City of Albuquerque Stormwater Construction Site Inspection Report

ESC File No.	J14E194	Project Name:	Hope Village		
NPDES Id. No.	NMR10033X; NMR10033N	Location:	1215 3rd St. NW		
5/25/2021	Owner			Contractor	
Operator	Hope Village, LLC.		Pavilion Construction		
Contact name & title	Michelle DenBleyker		Lexic Alexander		
e-mail	MDenBleyKer@yeshousing.org		lexalexander@pavilionconstruction.com		
Contact Phone #	432-530-7978				
COA Inspector	Thomas Evans		Start/End Time:	12:15 PM/11:45 PM	
Construction Phase:	Building construction				
Type of Inspection:	<input checked="" type="checkbox"/> Regular	<input type="checkbox"/> Storm Event	<input type="checkbox"/> Past Storm Event >0.25"	<input type="checkbox"/> 311/Complaint	<input type="checkbox"/> Follow Up
Weather at time of inspection?	clear		Temperature:	~ 78	
Estimated date of last storm 0.25" or greater	5/3/2021

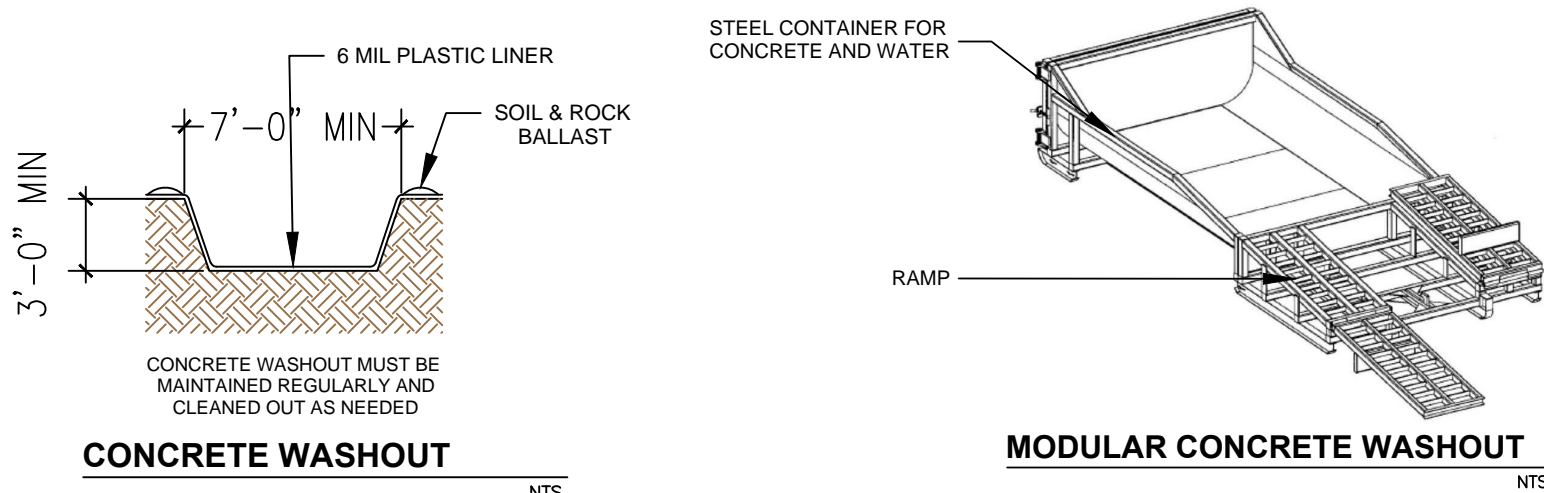
Item Number	Deficiency/ Corrective Action				
1	Track-out/sediment in the streets/sidewalk. Sweep track-out daily and remove sediment in the streets.				
2	Holes in silt fence. Replace/repair damaged silt fences.				
3	Domestic waste accumulated on East side. Remove domestic waste daily in an approved waste container.
